**COMMENT RESOLUTION FORM**

<b>Date:</b>	1/27/2022	<b>Disposition Codes:</b>	
<b>FHU Project Number</b>	117253-08 EPC Reviews 2022	<b>A. Accept Comment</b>	<b>E. Comment Conflicts with Previous Direction</b>
<b>Project Name:</b>	Briargate Blvd over Sand Creek Bridge	<b>B. Delete Comment</b>	<b>F. Designer to Evaluate Comment</b>
<b>Project Number:</b>	EPC PCD CDR2113	<b>C. Clarify Comment</b>	<b>G. Discuss Comment; Follow-up Required</b>
<b>Client:</b>	El Paso County	<b>D. Disagree with Comment</b>	
<b>Designer:</b>	Kiowa Engineering Corporation		
<b>Submittal:</b>	1/03/2022 Plans; 12/6/2021 Sand Creek Drainageway Design Report; 1/29/2021 Subsurface Soil Investigation	<b>Other Review:</b>	N/A

**C203**

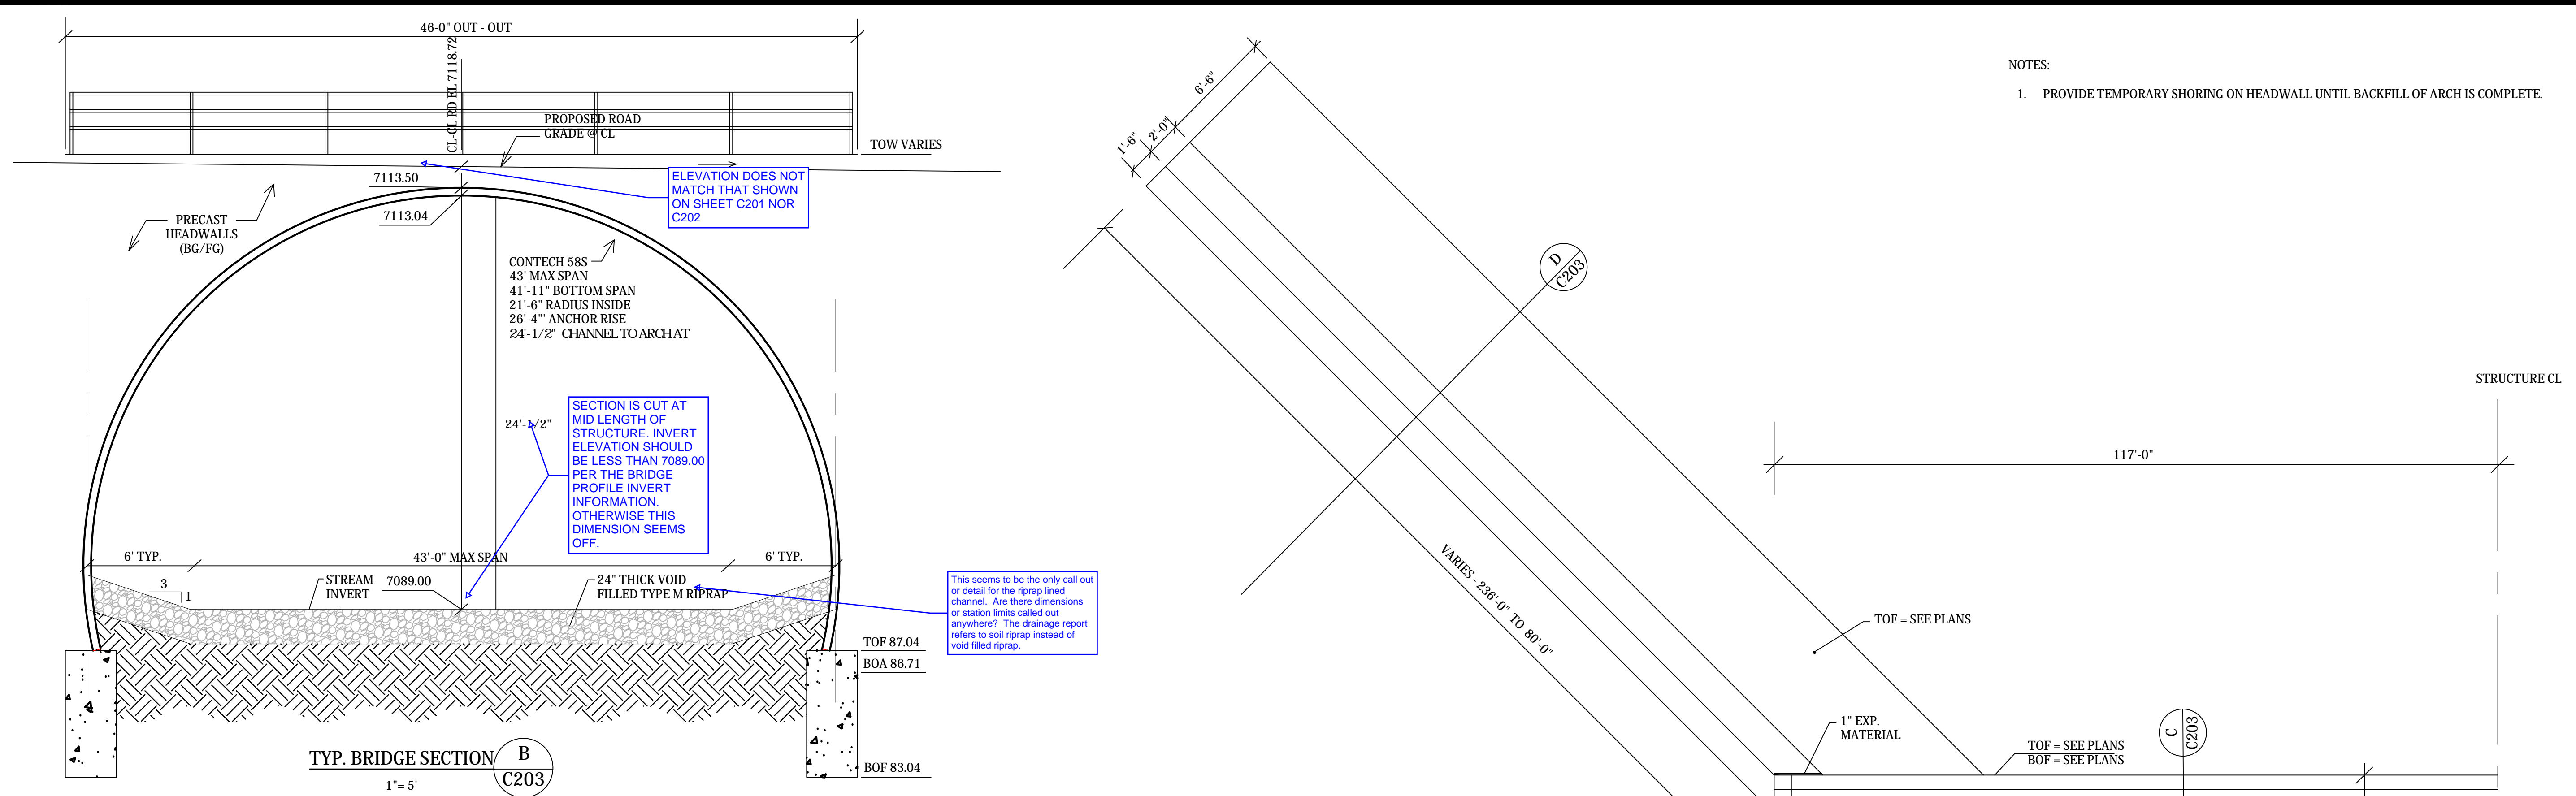
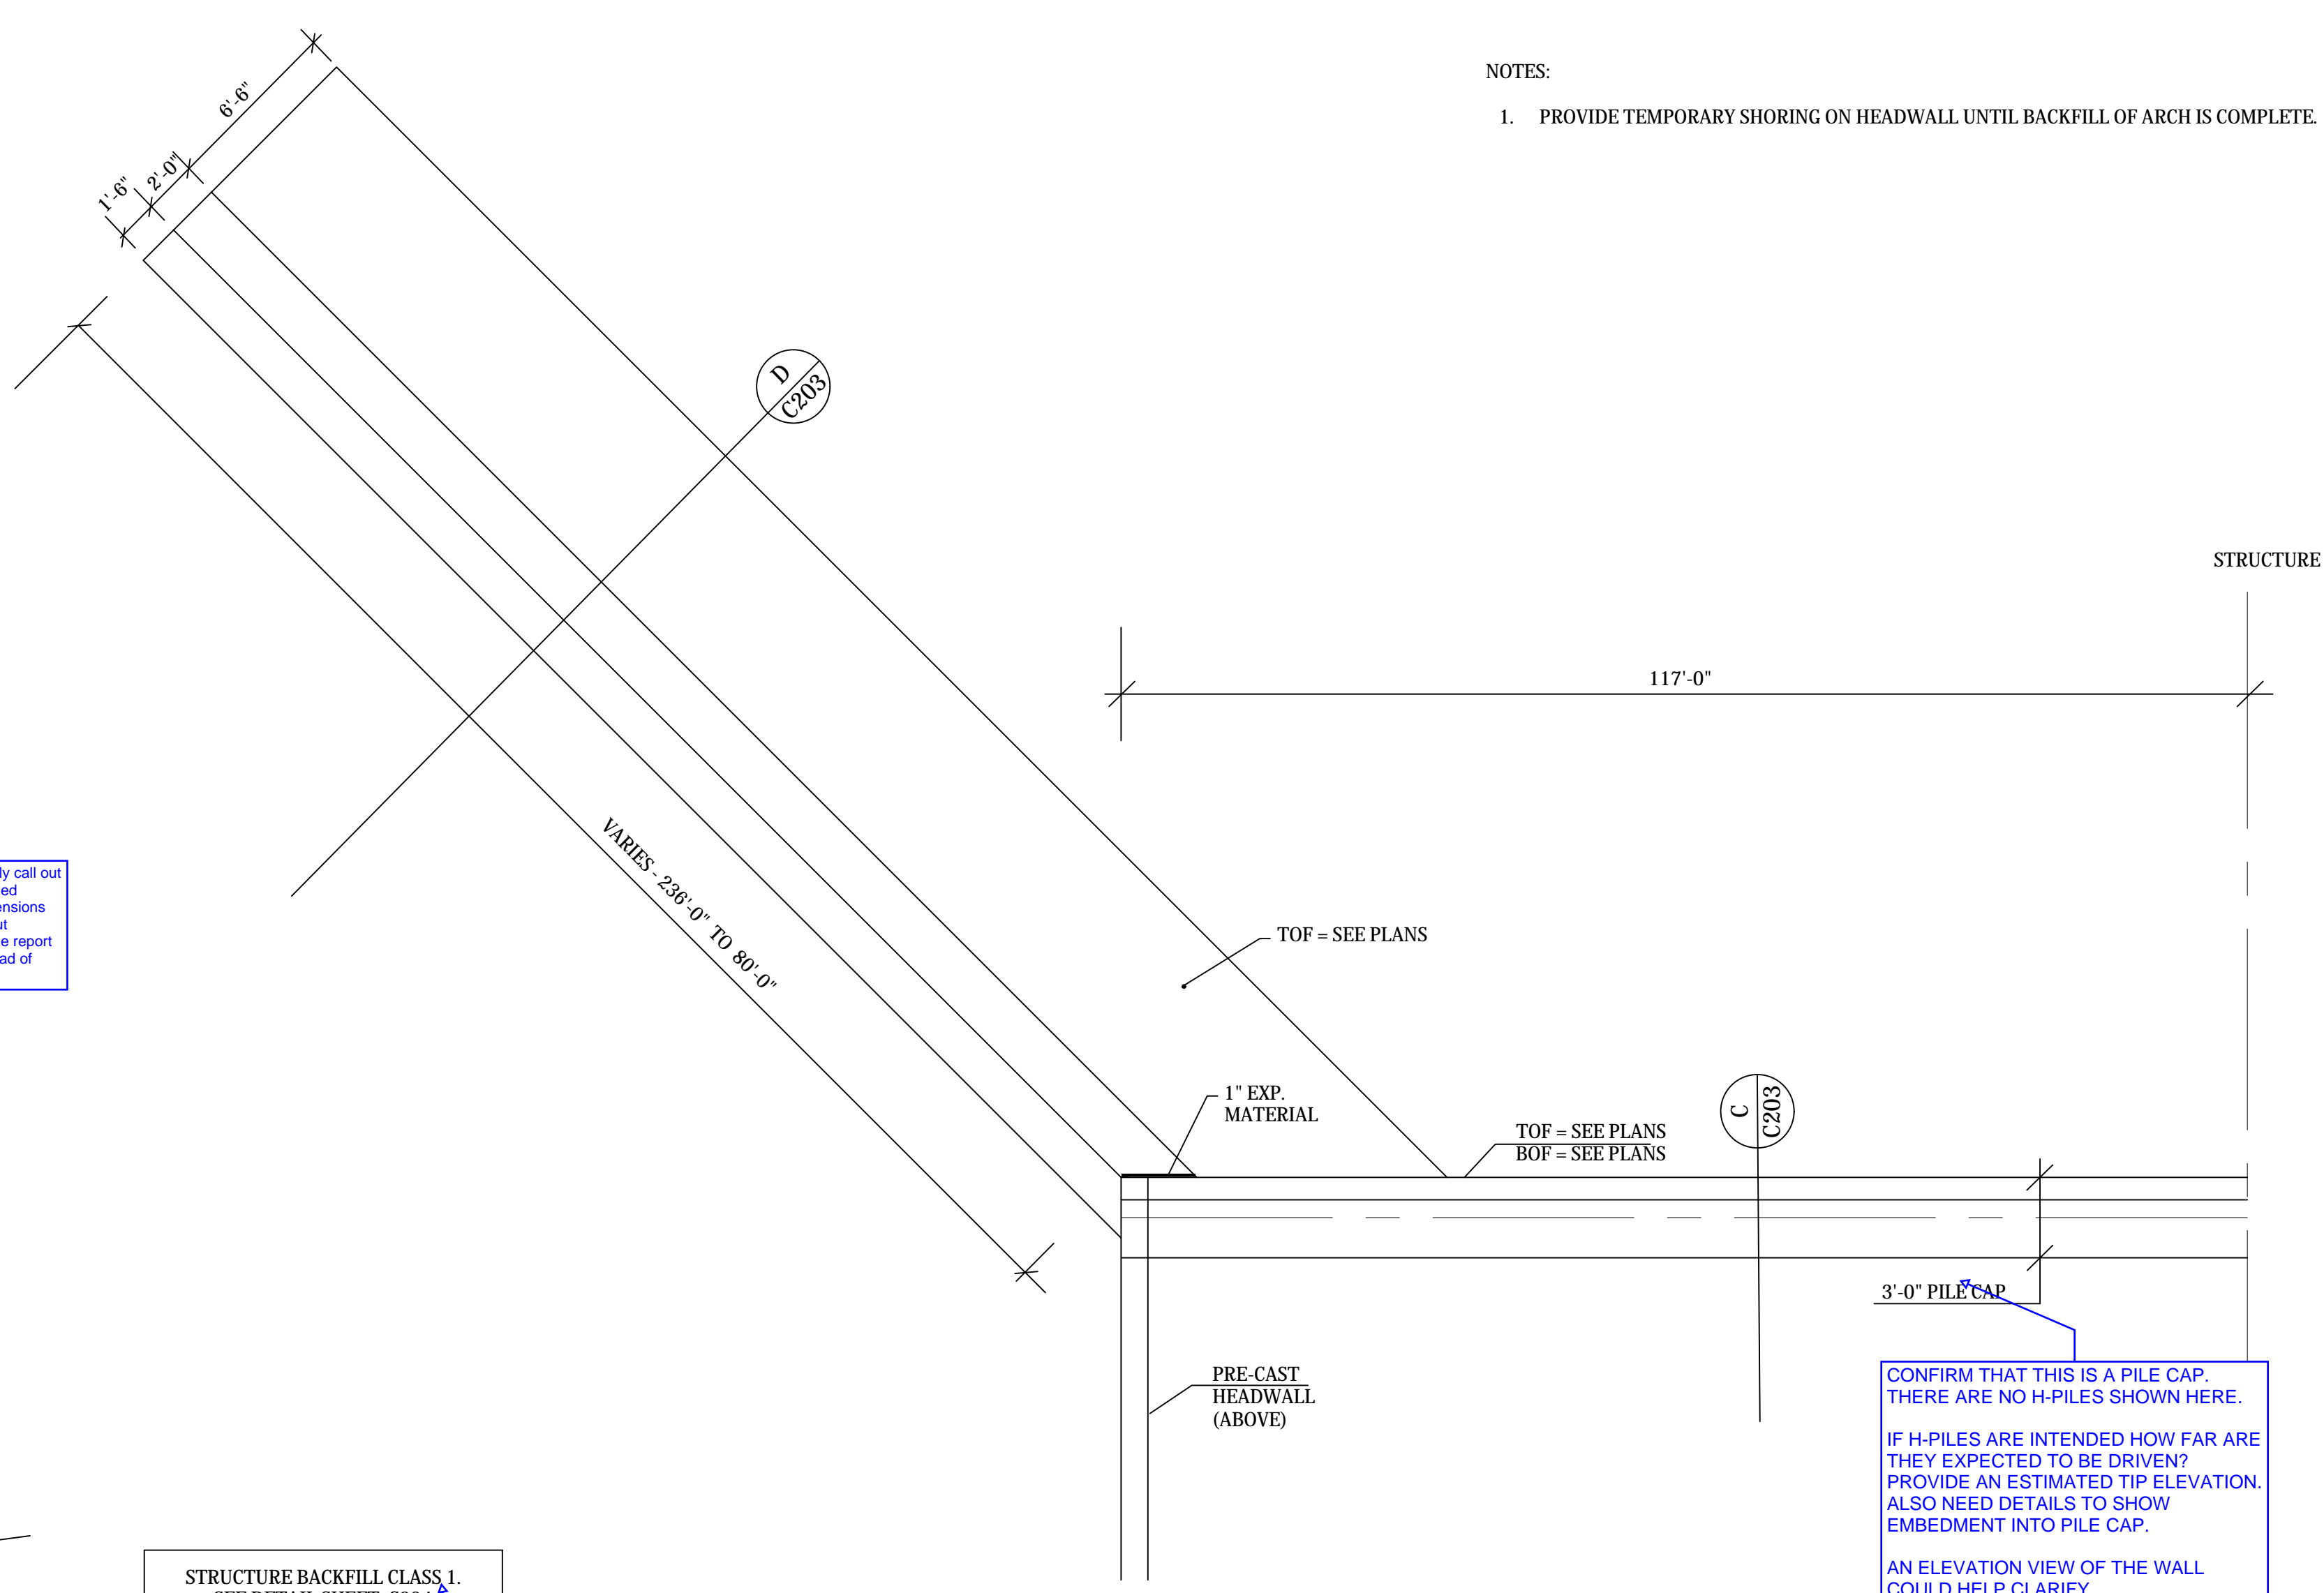
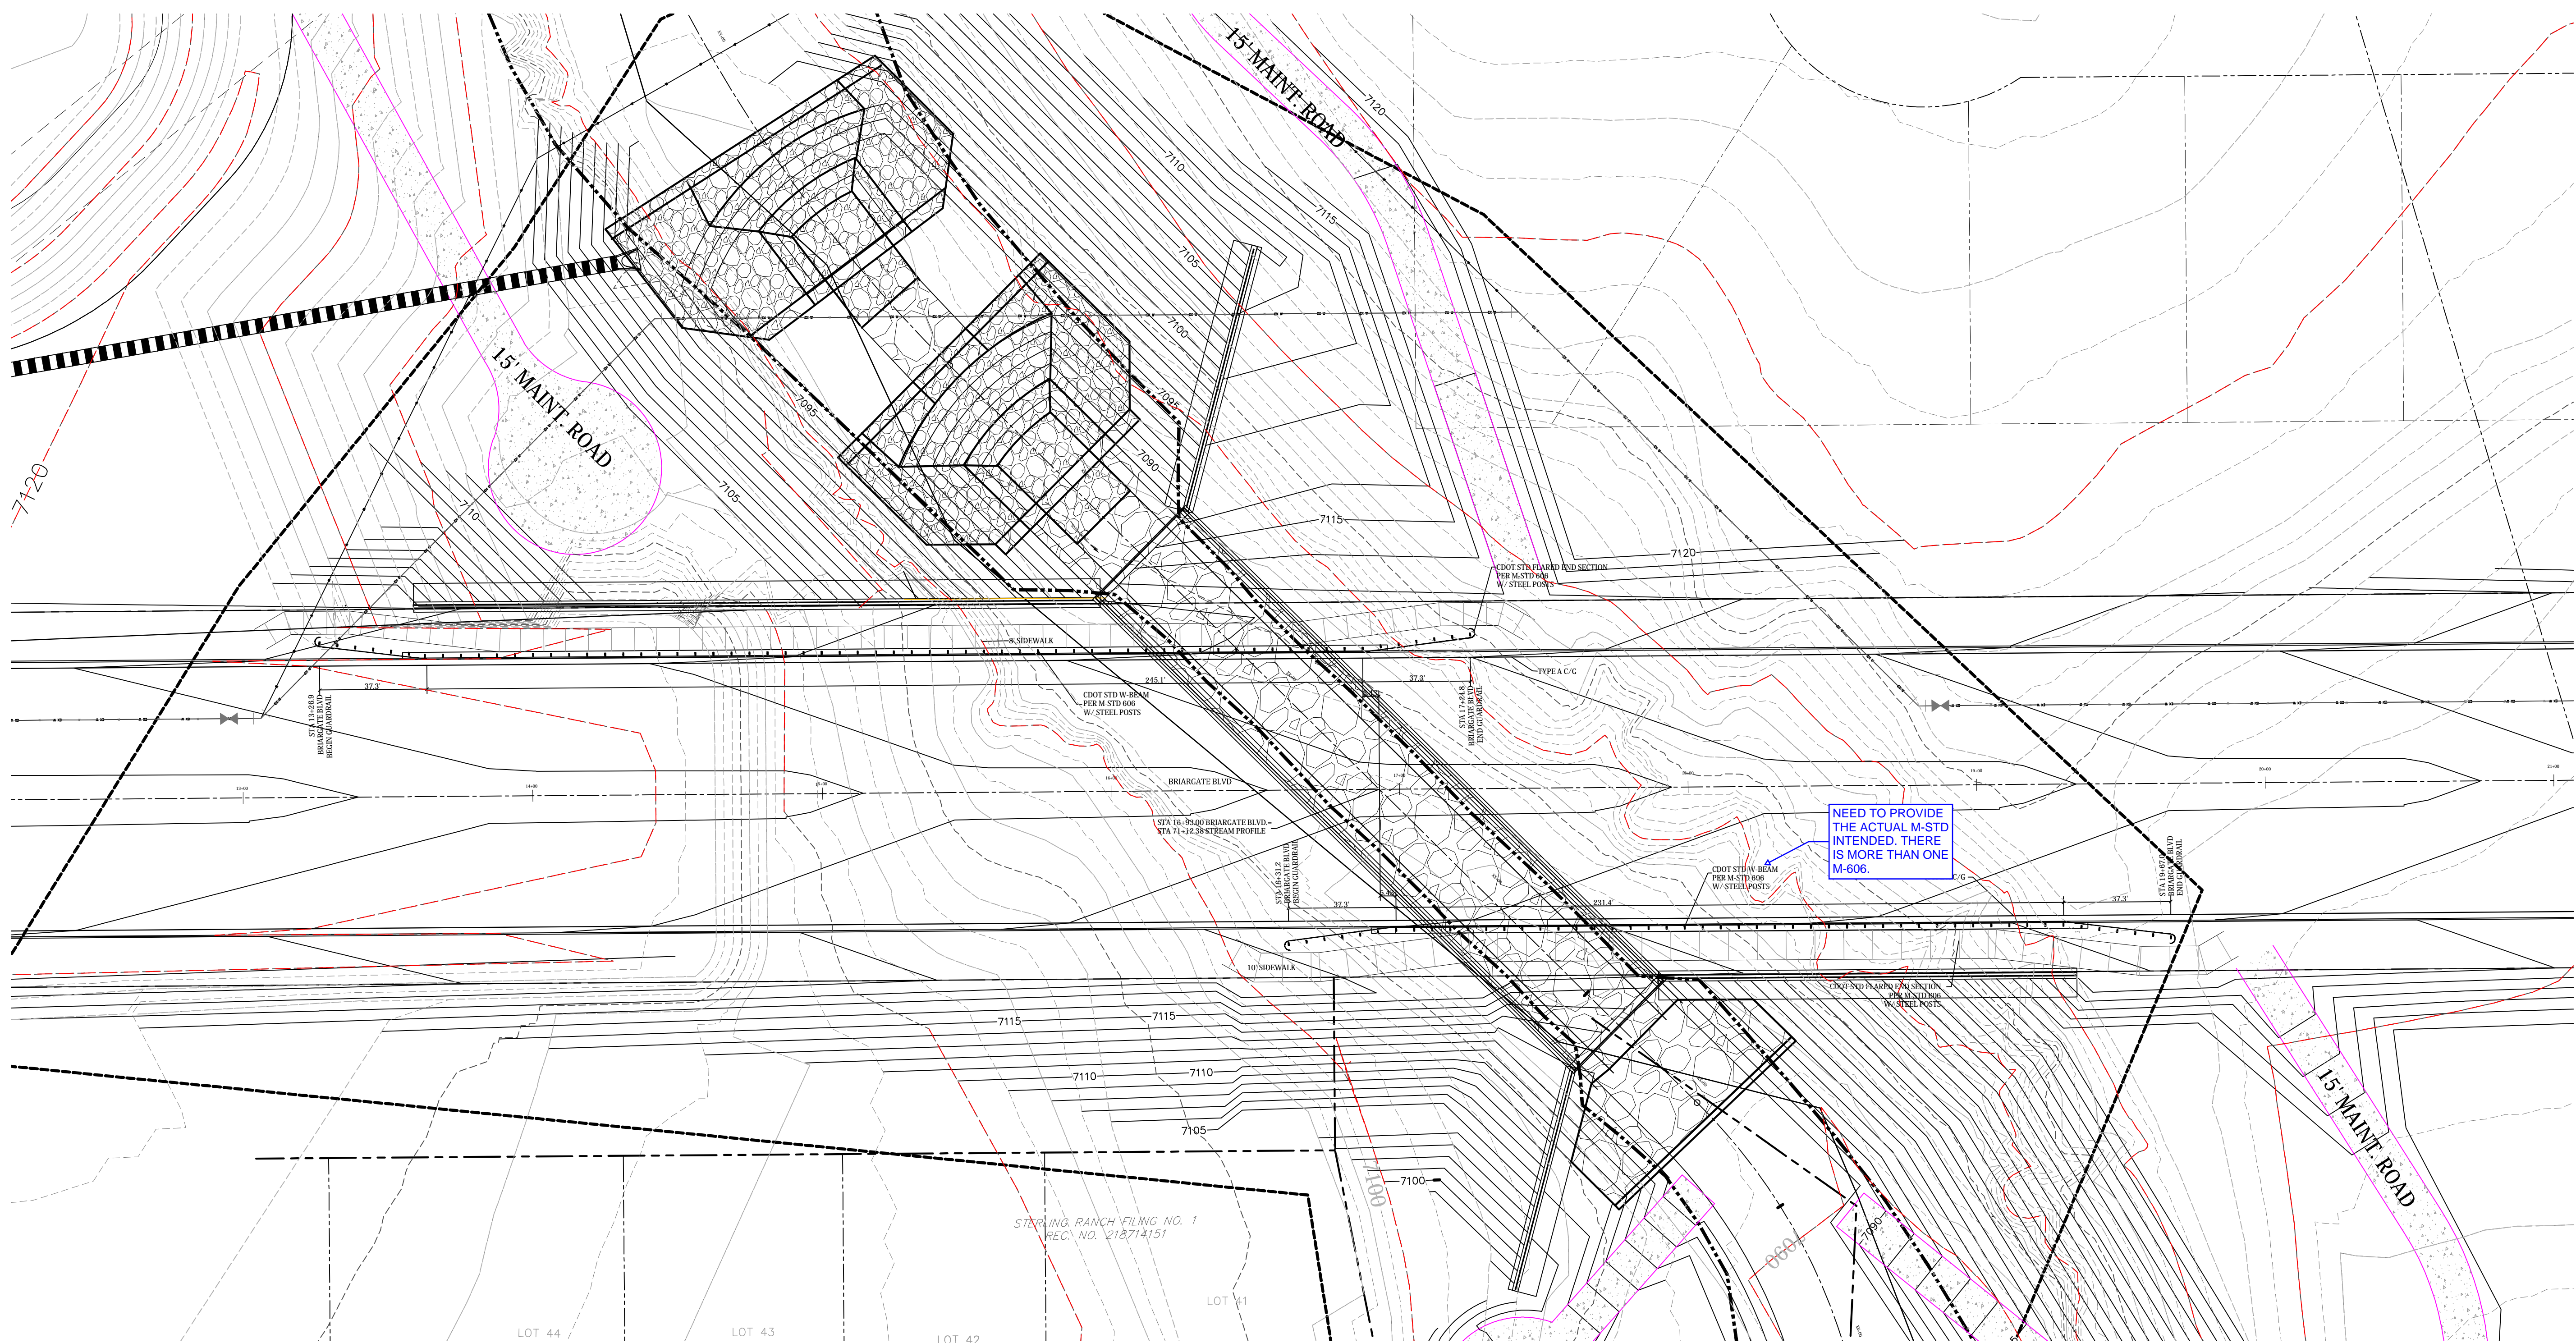
17	CAO	C203	Sheet not provided or this is mislabeled.						
18	CAO	C203	Show minimum dimension that weep hole shall be above finished grade.						
19	CAO	C203	CDOT required base of spread footing to be 36 inches below finished grade for frost protection. Confirm design geometry and dimension to meet criteria.						
20	CAO	C203	Unclear what this is pointing to.						
21	CAO	C203	CIP concrete walls should have expansion joints and control joints per CDOT and general engineering practice for long retaining walls. Provide details and notes.						
22	CAO	C203	Unclear which soil was assumed for design. Geotechnical report gives three different allowable bearing pressures for three different types of bearing soil. Include design allowable pressure in plans. However, it should be noted that CDOT and EPC require LRFD design and not ASD.						
23	CAO	C203	Design seems incomplete. Is this a spread footing or a retaining wall on H-Pile with pile cap? If the latter, additional details are needed. What is bottom of footing elevation at each wall?

24	CAO	C203	No H-piles are shown here not in foundation plan. Please clarify the design of this wall.

Reviewer Comments				Designer/Consultant Response			Final Disposition		
Comment No.	Reviewer	Sheet/ Page No.	Comments	Initial Code	Date	Response	Code	Date	Initials
25	CAO	C203	Confirm that this is a pile cap. There are no H-piles shown here. If H-piles are intended, how far are the expected to be driven? Provide and estimated tip elevation. Also need details to show embedment into pile cap. An elevation view of the walls could help clarify.						
26	CAO	C203	Geotechnical report states that expansive soil could be encountered in some areas. How is this being handled for the Conspan structure foundations and wingwalls?						
27	CAO	C203	Suggest providing details showing the excavation recommendations outlined in the geotechnical report for structures and foundations.						
28	CAO	C204	Need to provide the actual M-Standard intended. There is more than one M-606.						
29	CAO	C211	How does the precast fabricator know the dimensions of the headwalls? Suggest providing basic elevations and dimensions to assist in the shop drawing development.
